Attached are comments made in response to Action Point 27 Colne Valley North:

Document: 8.4.12.2 Response to ISH2 Action Point 27 - Masterplans

Planning Inspectorate Reference: EN020027

Action Point 27: Colne Valley (north Fordham) – Draft Opportunities Plan Comments

Action Point 27: Colne Valley (north) – Draft Opportunities Plan

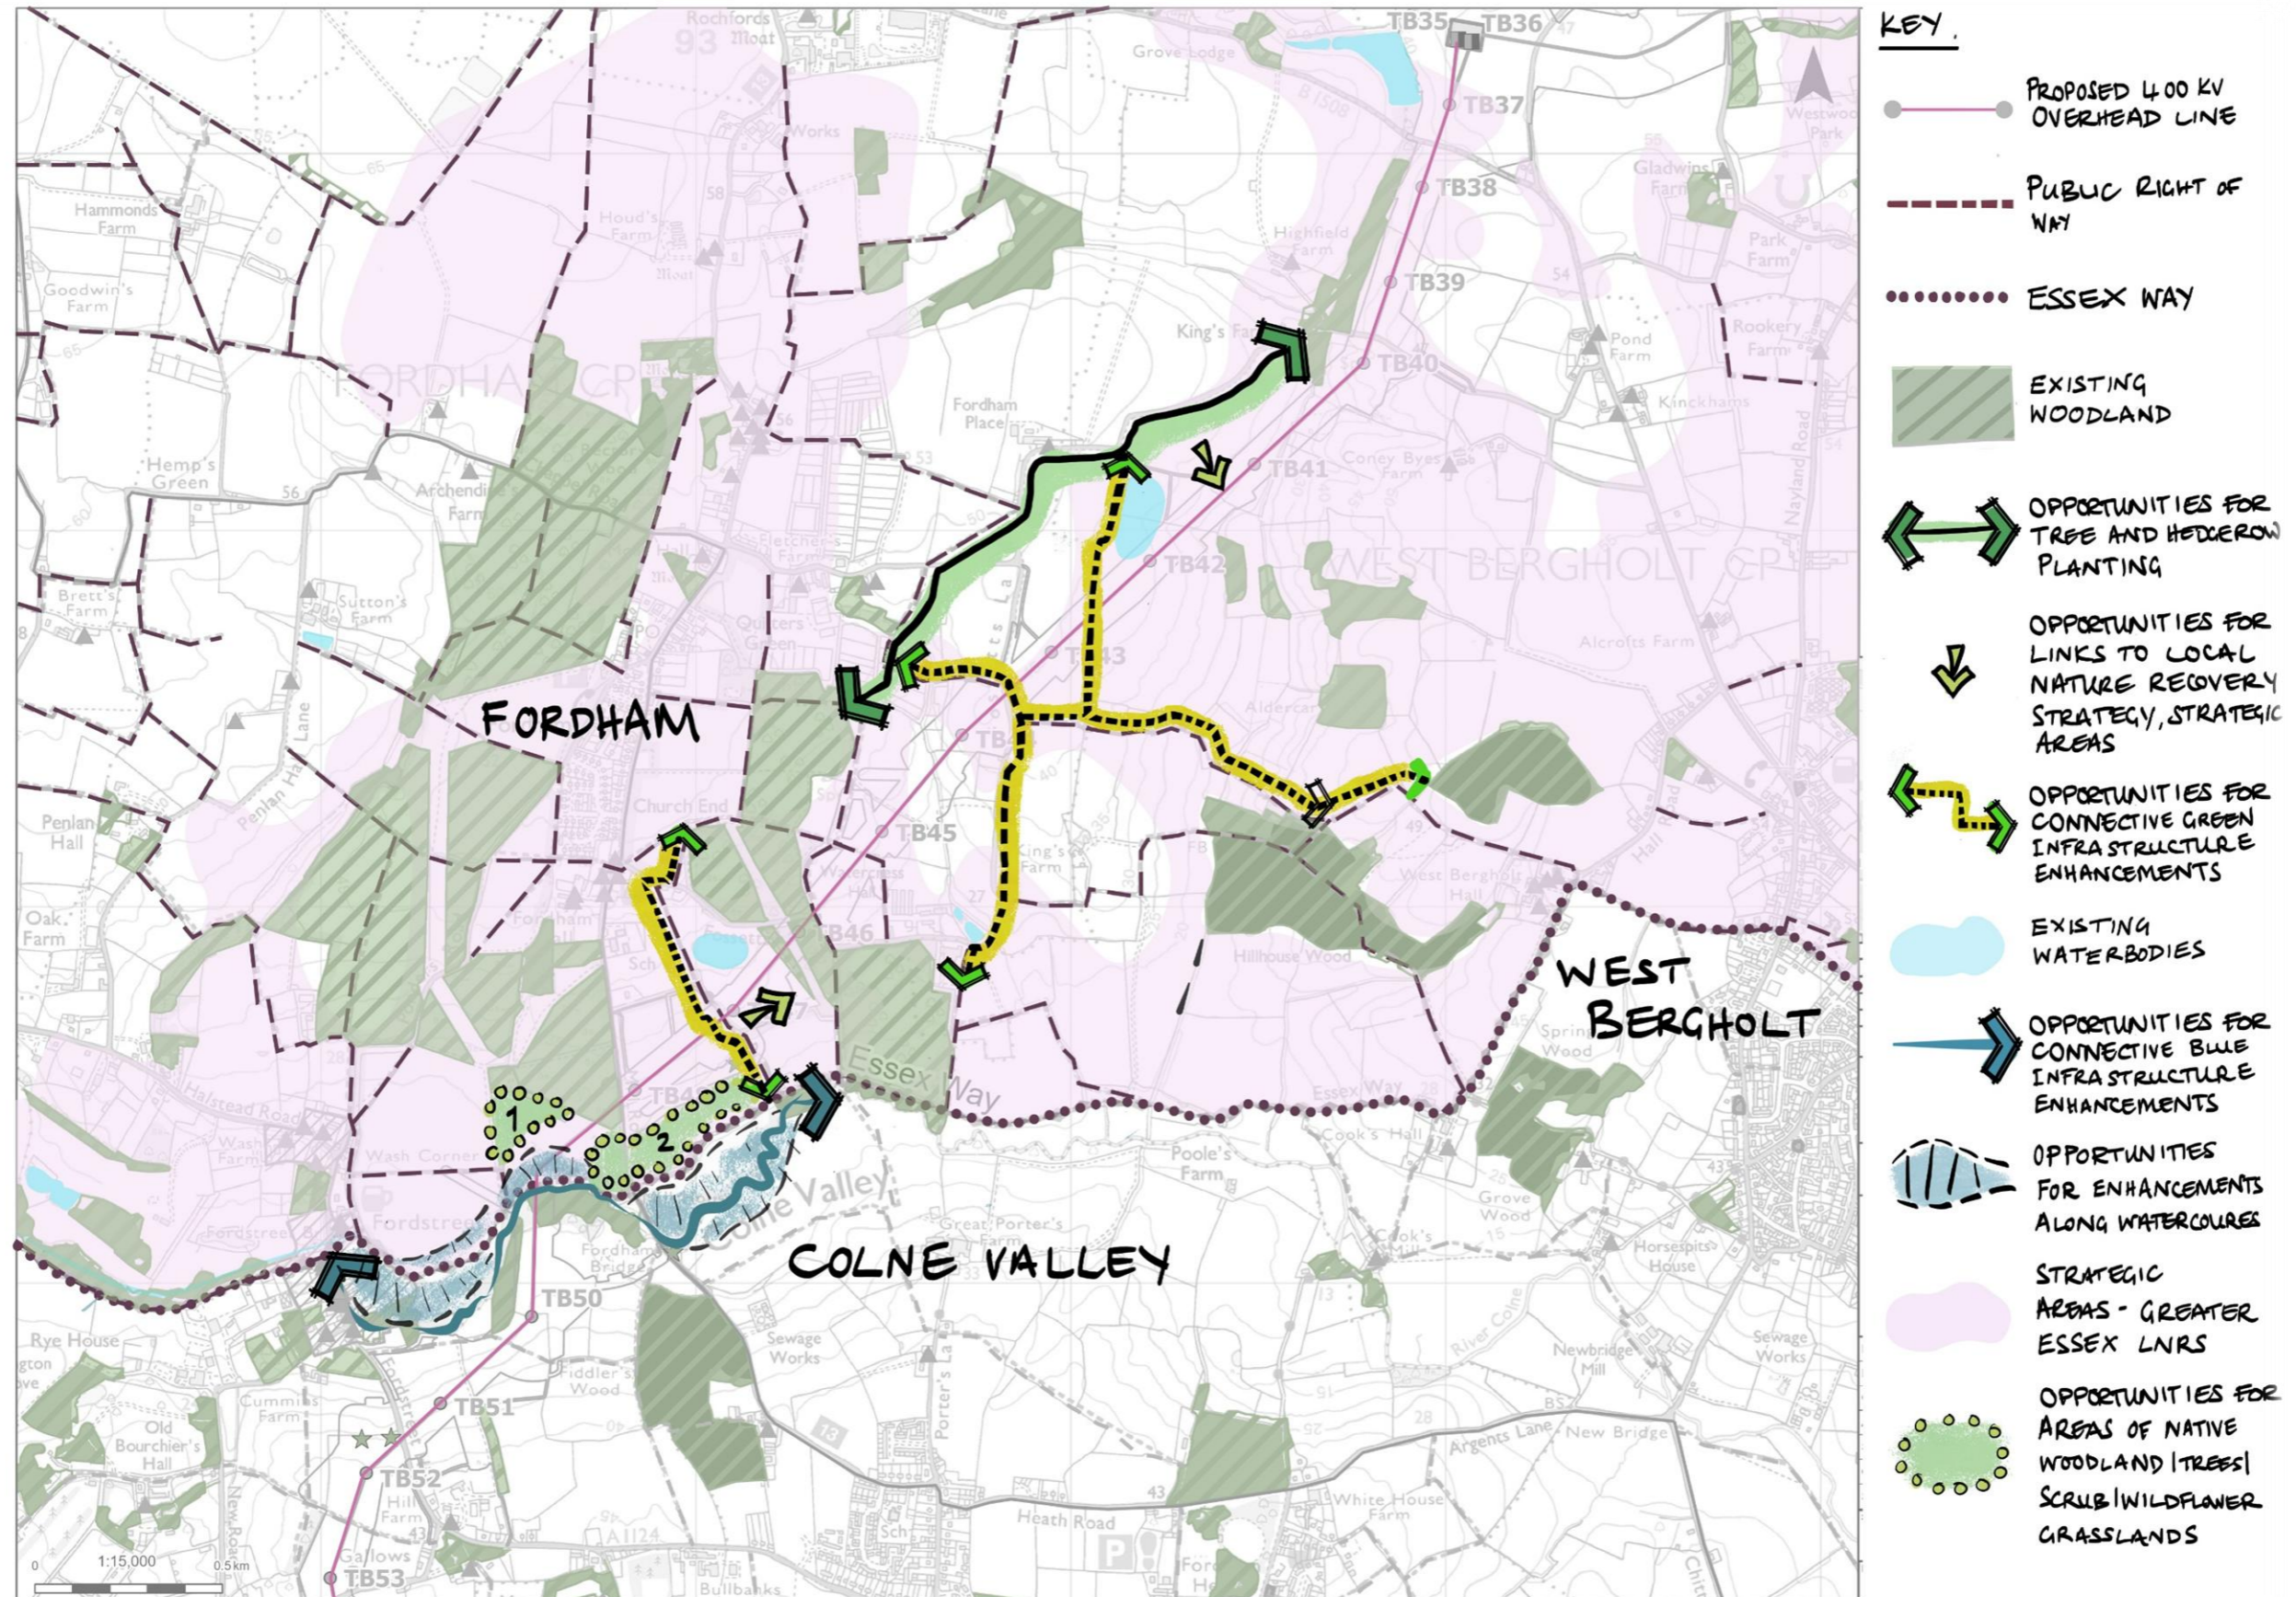
1. The draft plan presents a number of environmental enhancements which, on closer examination, are either existing habitats, existing management by third parties, or projects already being undertaken by others. As a result, the plan gives the impression of delivering environmental gain where little or no genuine additional enhancement is actually proposed.

Section 2.6.1 appears to undermine the credibility of the Draft Opportunities Plan, as it acknowledges that many of the proposed opportunities are on land owned or managed by third parties who have not agreed to these proposals. **The reality is they haven't proposed anything of genuine new enhancement to the environment.**

2. The map is such poor quality it is hard to read, even for those who know the area!
3. The map is misleading, it does not show the full extent of Woodland Trust land and, as such, makes it look like NG are proposing enhancements in areas not already being maintained by the WT.

4. Does the title 'Draft Opportunities Plan' indicate that a more detailed plan will be produced for consultation? The current plan is extremely vague and provides insufficient detail for meaningful consultation. Furthermore, does the repeated use of the term 'opportunities' indicate that these measures are merely potential options rather than firm commitments? If so, what criteria will National Grid apply in deciding whether these opportunities are actually delivered, and what guarantees are there that they will be implemented? For example, what is meant by 'Opportunity for links to LNRS strategic area' and 'Opportunities for connective blue infrastructure'?

5. The 'Opportunity for connective green infrastructure enhancements' areas shown on the map already have hedgerows so it's not an opportunity as it already exists.

6. Areas 1 and 2 detailed on map as 'Opportunities for areas of native woodland, trees, shrub, wildflower grassland' are already within and the Woodland Trust area of land and being managed by them in this way.

7. The flood plain area near to Fordham bridge marked as 'Opportunities for connective blue infrastructure' has already been developed, with scrapes, ponds, channels and lowering of riverbanks to reduce the risk for flooding and increase biodiversity through establishment of wetlands. The aim of the Woodland Trust is to achieve official designation.

8. The area marked as an 'Opportunity for tree and hedgerow planting' already has some hedgerow, but the remaining area is open that allows for travellers to enjoy the wonderful views

across the valley. Creating a hedge would further block the views that are already to be blighted by pylons and further change the character of this beautiful part of the village.

9. If NG plant hedgerows along roadsides, do they intend to maintain those hedgerows to prevent growth and obstruction onto the highways?
10. There needs to be communication with Fairfield Farms as hedgerow planting appears to occur in an area where they have laid pipes and sunk infrastructure which connects with the agricultural reservoir.

11. The plans do not identify where existing hedgerows and mature trees will be removed as part of pylon construction, nor do they make clear whether the proposed “opportunities” are intended simply to compensate for habitats that National Grid itself will destroy. If this is the intention, the plans should state this explicitly. Furthermore, the use of the word ‘restore’ is misleading. Once mature trees, established hedgerows and long-established habitats are removed, they cannot be restored within any meaningful timescale. Newly planted trees and hedgerows cannot replicate the ecological value, biodiversity, landscape character or visual screening provided by mature vegetation for many decades. Any proposals should therefore distinguish clearly between genuine restoration and replacement planting.

The full extent of Woodland Trust Land. The river enhancements are already in WT land and are something WT have already constructed!
